WEST SUSSEX COUNTY COUNCIL

SUBJECT: LU/257/08 - COU from offices to ground floor restaurant and first and second floor flats

26, High Street, Littlehampton, West Sussex

RECOMMENDATION:

PROPOSED FIRST FLOOR PLAN

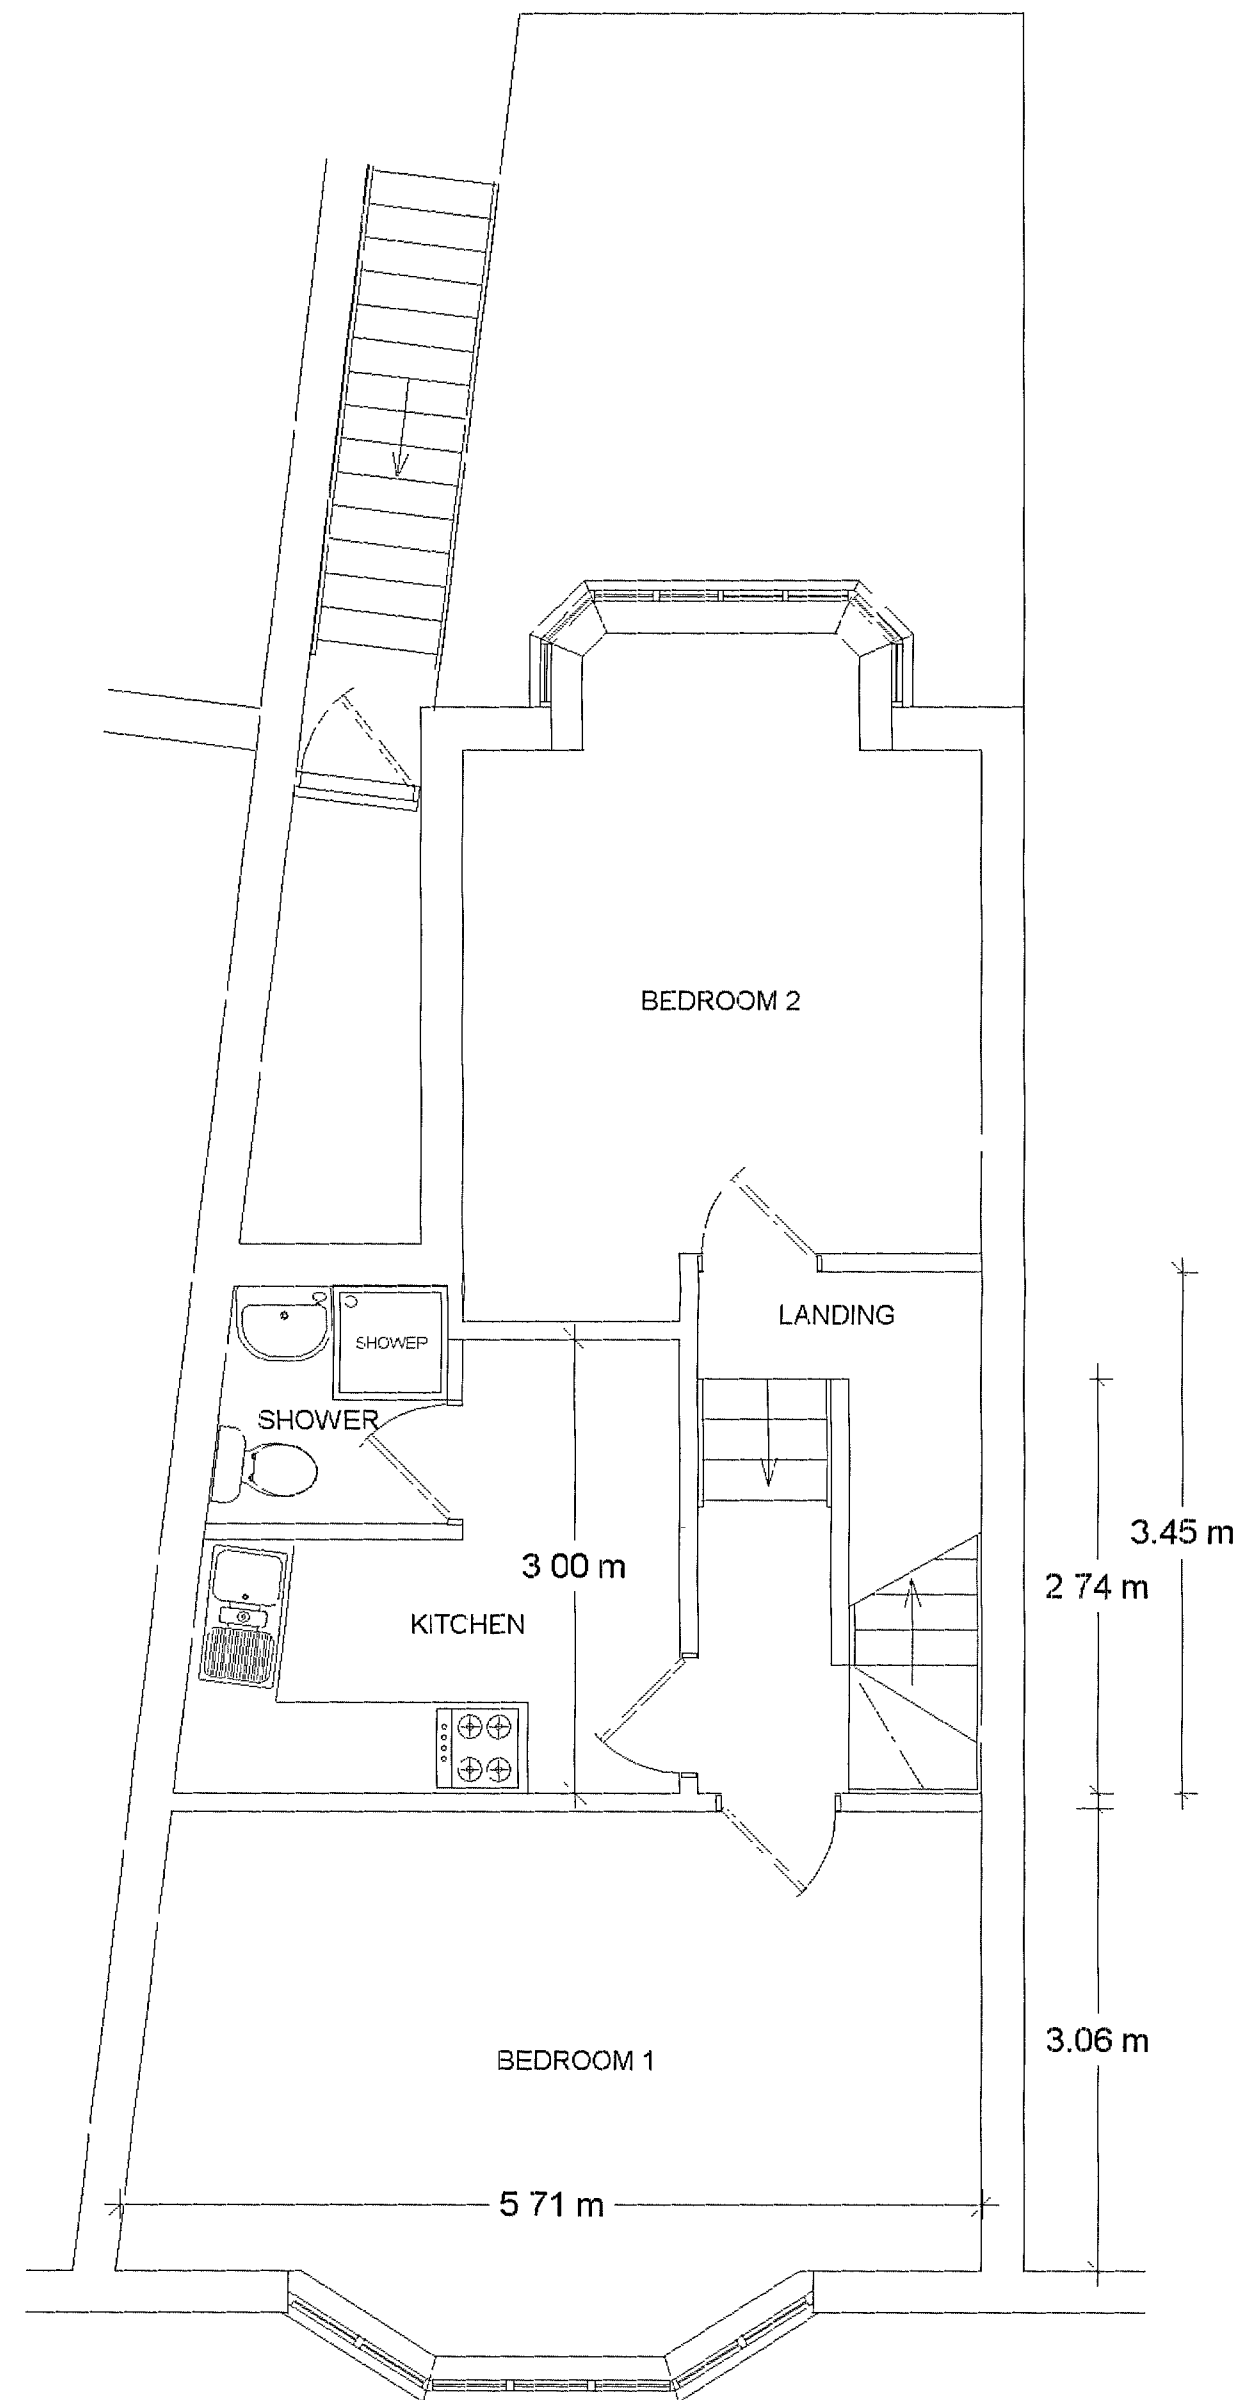
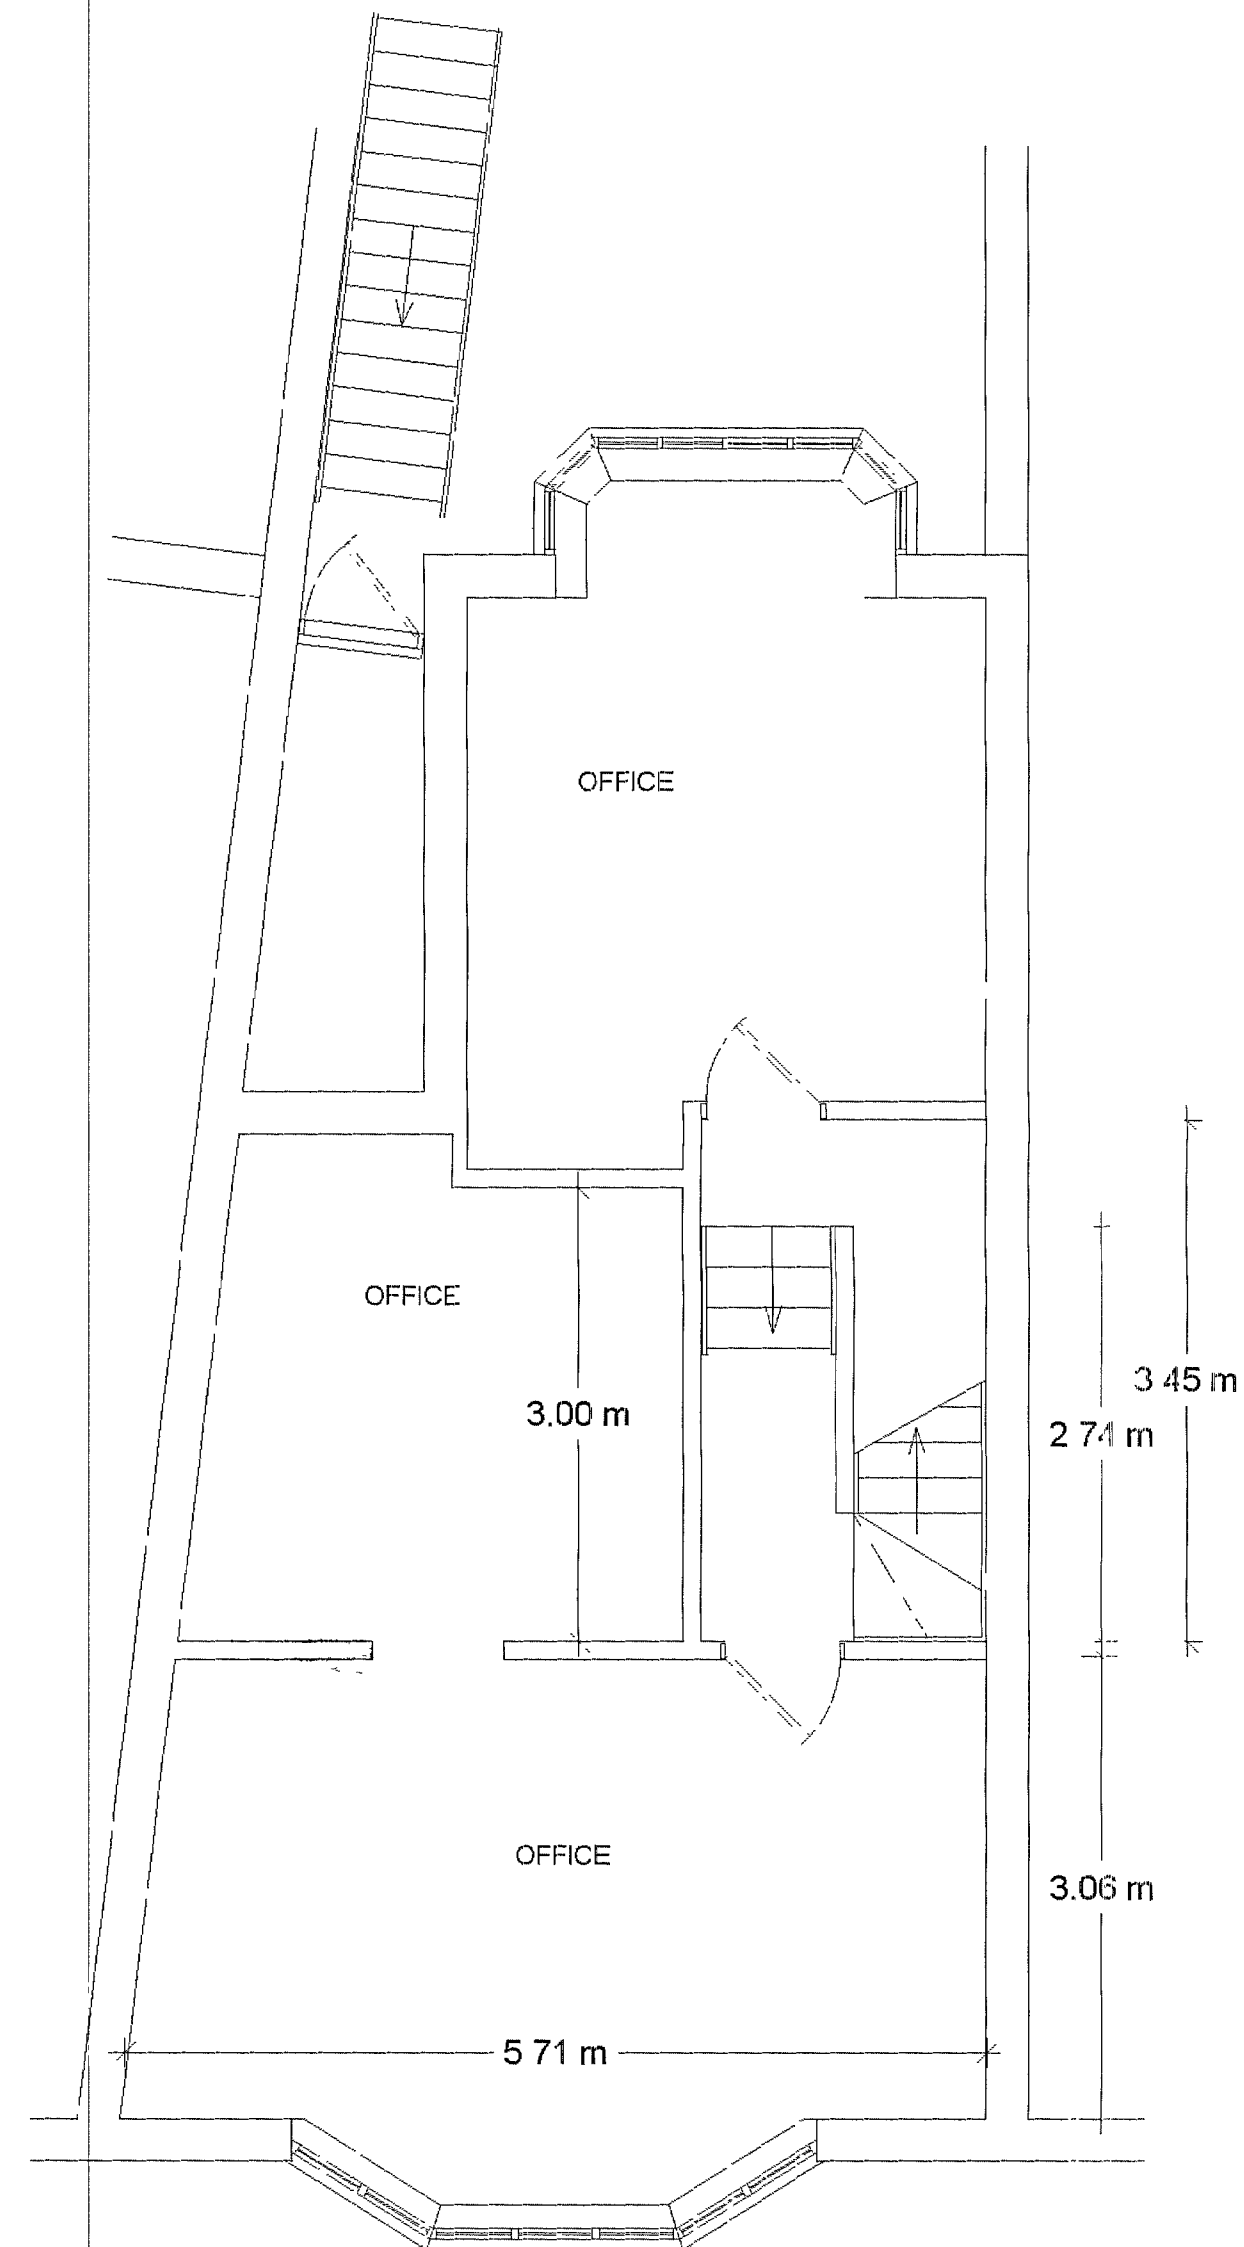
The application states that there are proposed to be five flats with four or more bedrooms; this does not appear to be the accommodation as shown on the drawings. It is not proposed to provide any vehicle parking and cycle parking provision is not mentioned.
